**DEVELOPMENT CONTROL
Arun District Council
The Arun Civic Centre,
Maltravers Road,
Littlehampton,
West Sussex
BN17 5LF**

**Ian Ronald Lloyd
3, Elmer Court,
Elmer Sands,
Middleton-on-Sea,
West Sussex
PO22 6JT**

**PLANNING APPLICATION HOUSEHOLDER.....APPLICATION NO. M/62/17/HH...
Replace two storey extension & erection of rear balcony & external staircase
at 2, Elmer Court, Middleton-on-Sea**

Section

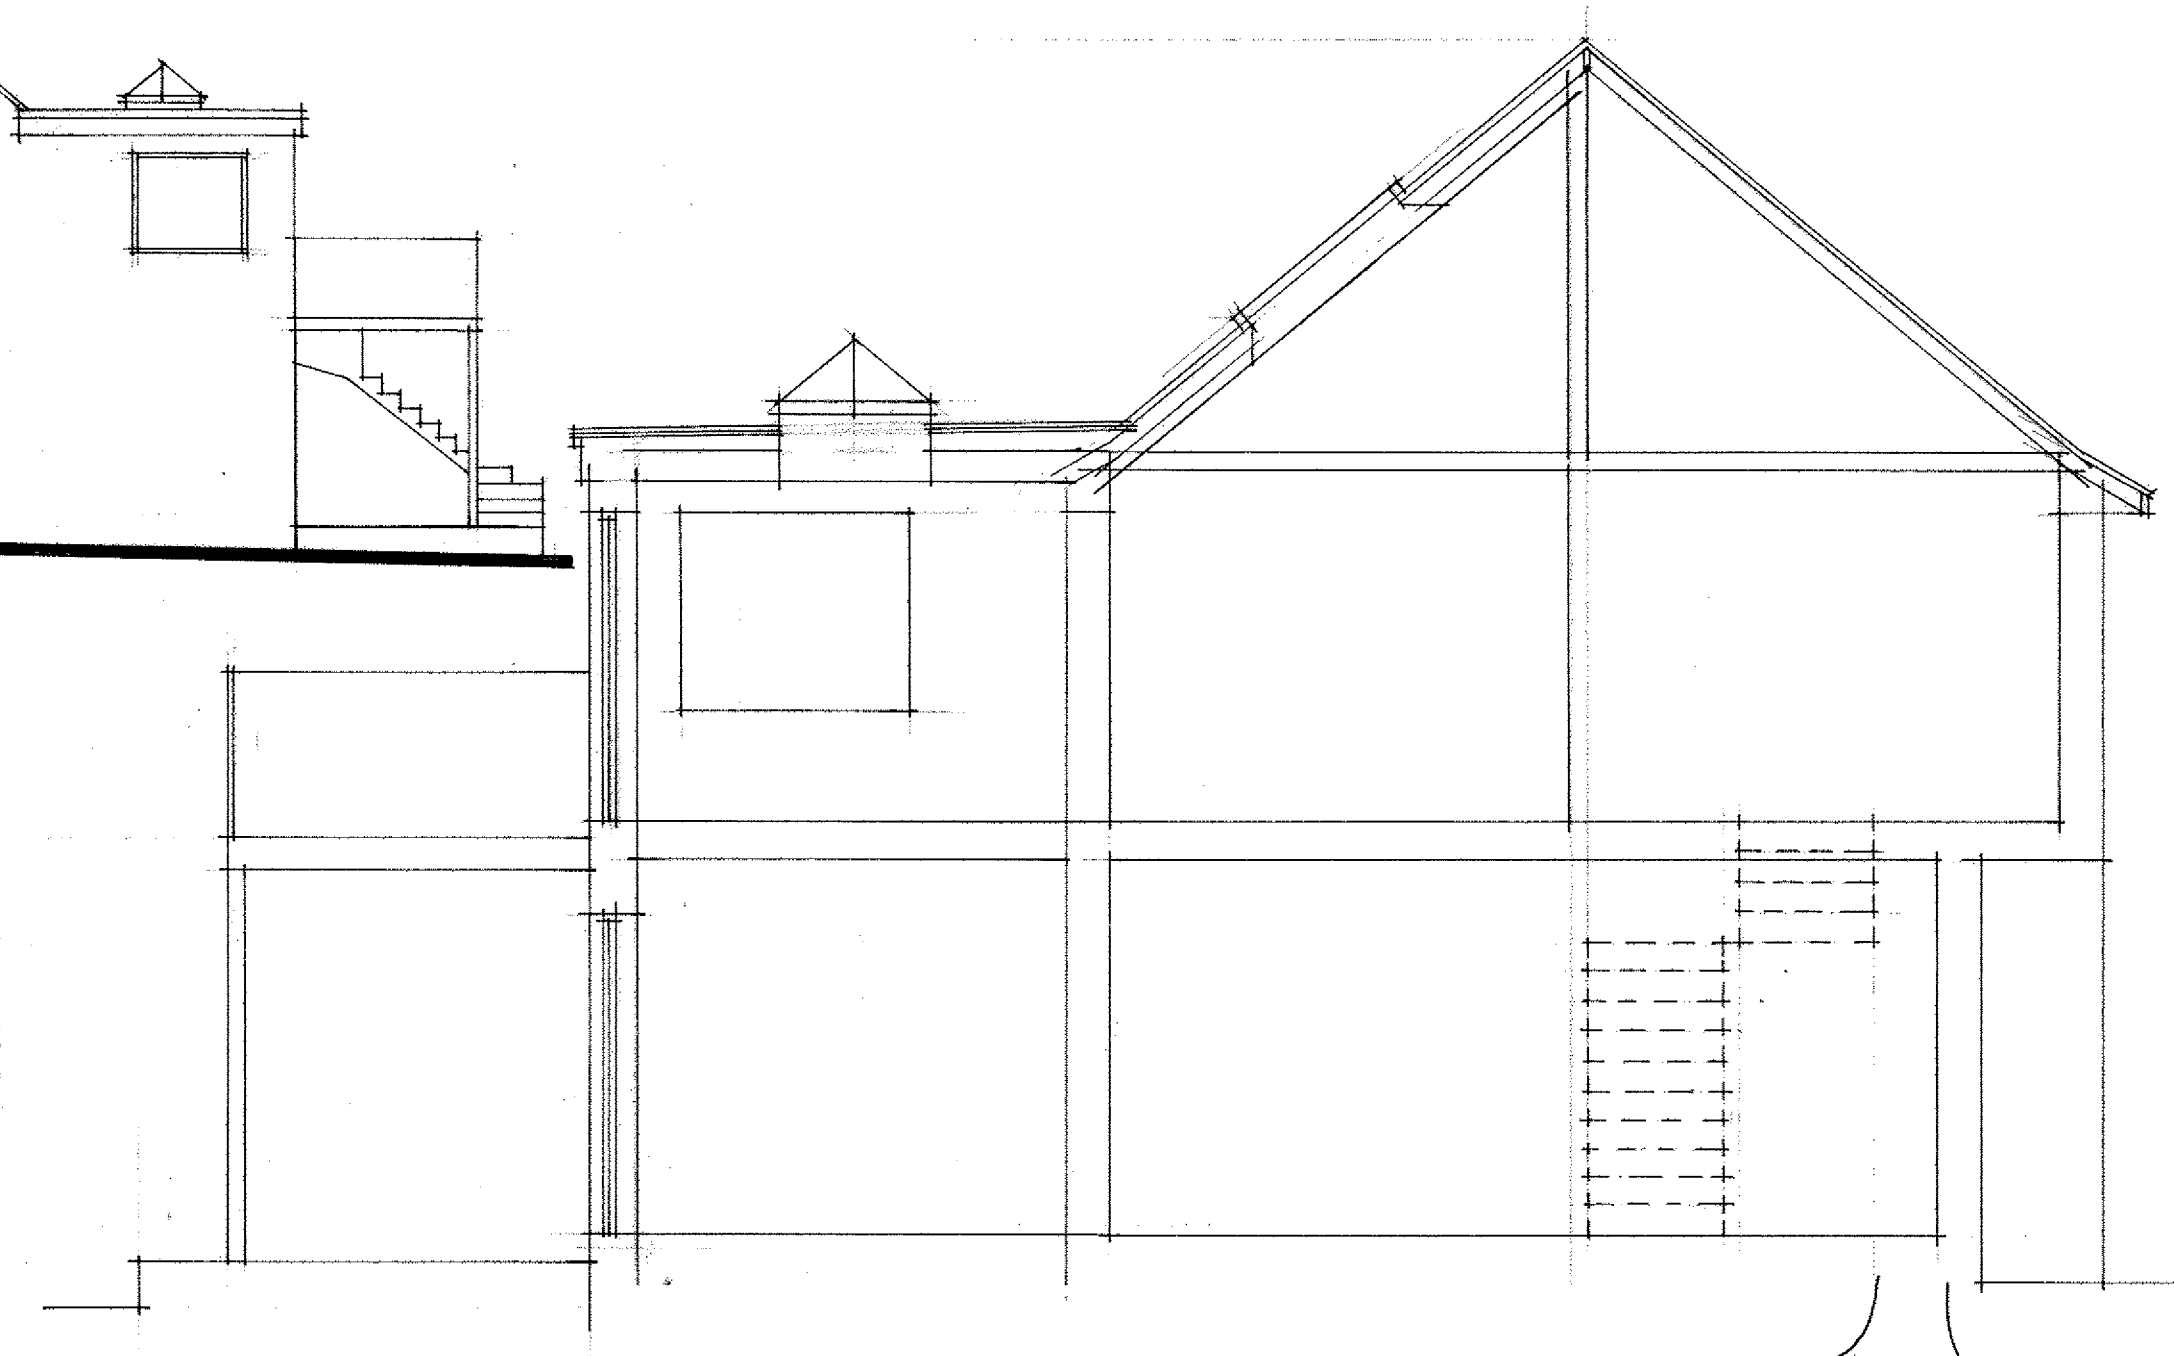
- (1) Effect on the daylight and privacy of my property..... Possibly, but only very slightly. The two storey extension is being rebuilt only slightly larger than existing. The proposed balcony extends only 2.4 metres (approx.) further south from the two storey extension.**
- (2) Design, appearance and layout.....I believe Planners look at the design and appearance of balustrades. I have no observations.**
- (3) Flood Risk..... The rainwater from the flat roof of the existing two storey structure discharges into a hopper and rainwaterpipe and then to a soakaway. I assume that will remain the same with the new structure although the rainwater pipe will need to be repositioned and alteration made to the connection below ground. In respect to the discharge of rainwater from the proposed balcony I assume a similar method will be provided.**
